Refs 2022/93234 LBC museum, 2022/93235 LBC Queensgate Market & art gallery & 2022/93248 Piazza

I wish to give my general support to the application and want to comment on some issues.

- 3.5.1 Thermal enhancement of the external envelope- retained east elevation
- 3.5.2 Thermal enhancement of the basement area including building structure
- 3.5.3 Stair through panel 10 onto Queensgate
- 3.5.4 Sculpture 'Commerce' relocated
- 3.5.5 Landscape to the east of the ceramic panels

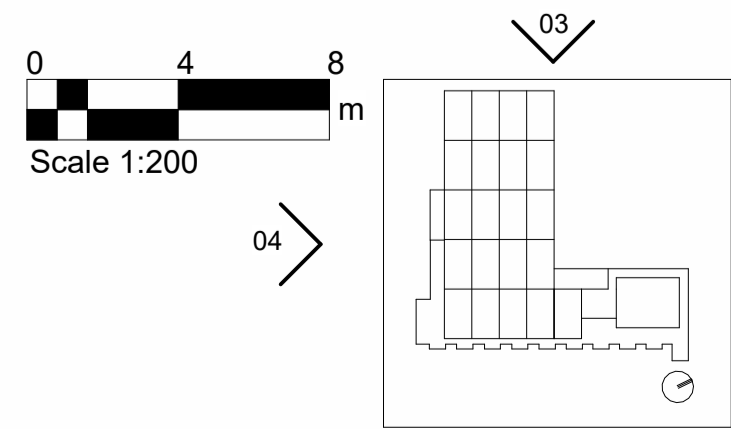
See also 2022-93235_Plan+General_954577 3.5.3 Stair through panel 10 onto Queensgate

I have been unable to find any justification for this work in the application to a listed heritage asset.

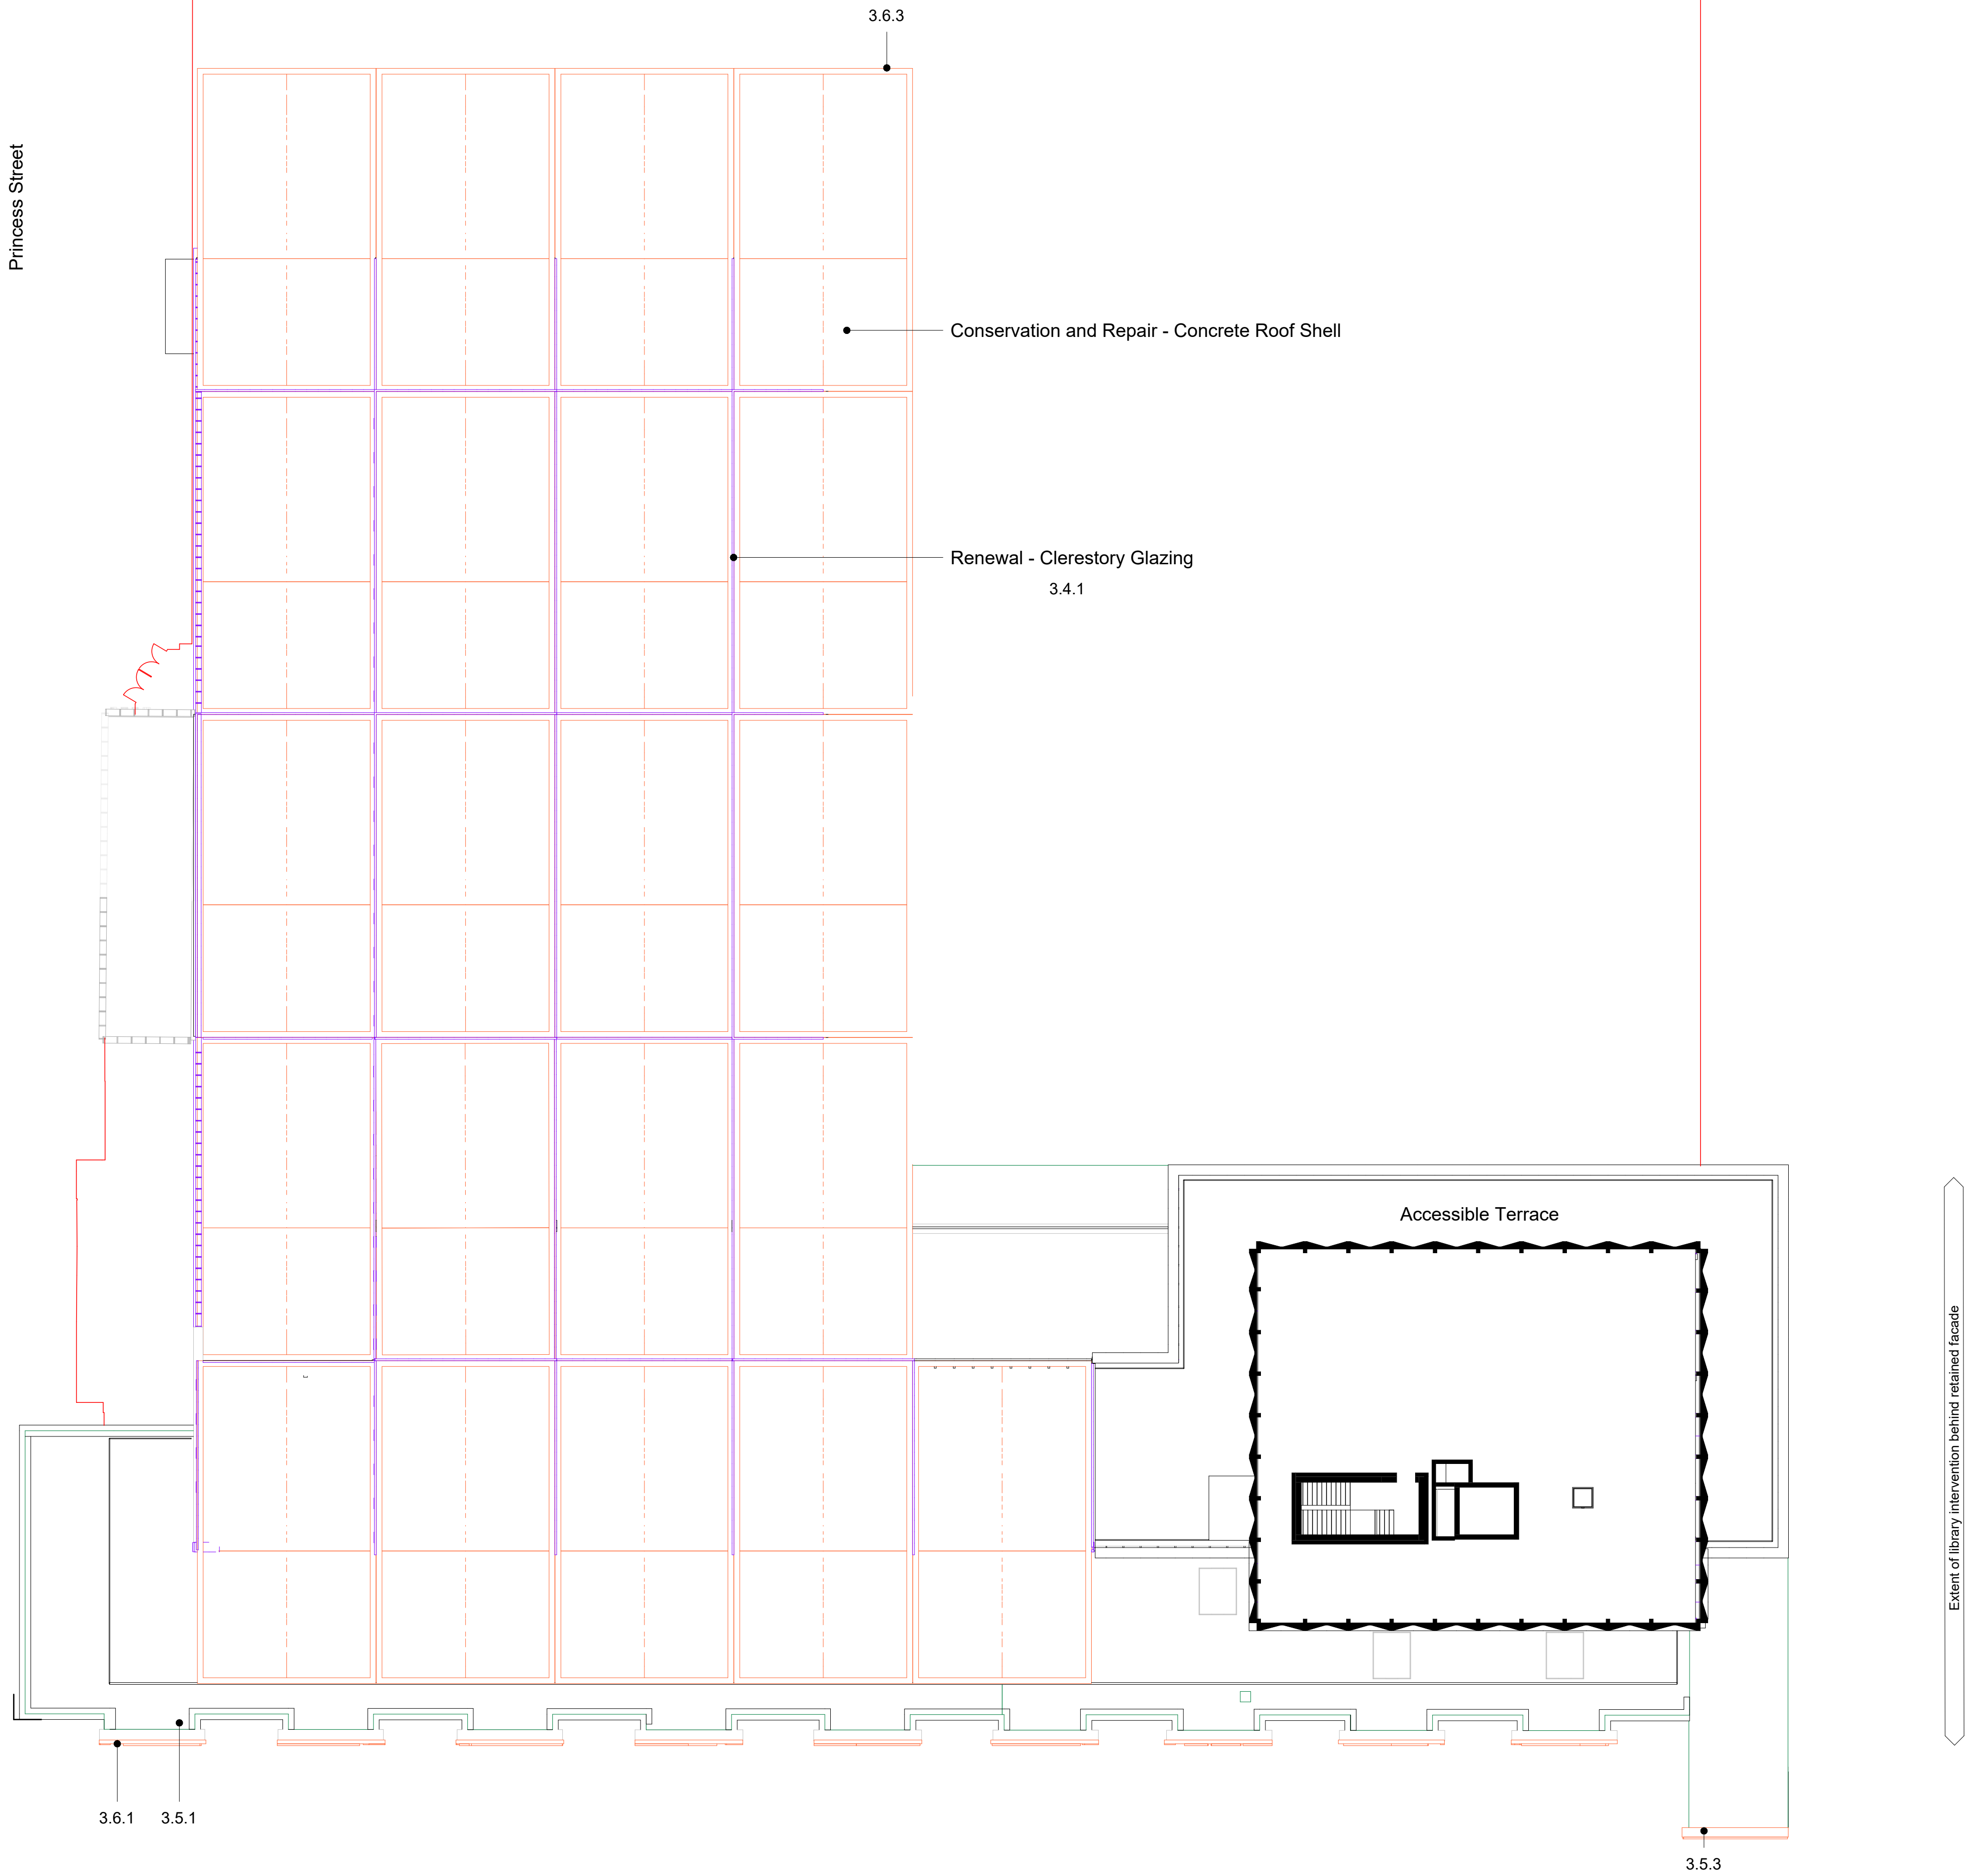
1. The application seems to disregard the significance of the grade II listed staircase through ceramic panel 10 onto Queensgate.

The form and geometry of the 1970 staircase was extraordinary with an apparently unsupported raw concrete stringer beam, pale Ballidon limestone with a glistening quartz-like material concrete riser and tread ends with occasional but regular ballusters bearing black profiles.

The staircase and extended quarter landing were designed and built as 'floating' cranked hidden spine-stringer supporting flights of steps with 'floating' balustrading and handrail. Achieved without newel posts or many spindles and at first sight not meeting the walls. The spindles are minimal without compromising the structure and the handrail had hidden supports to masonry.

The proposed alterations are described in manner I don't understand but disappointing as the 1970 design is disregarded. See 2022-93235_Plan+General_954570 "Note 16. Existing stairs with new metal balustrade with vertical flats".

I hope restoration work can be conditioned.
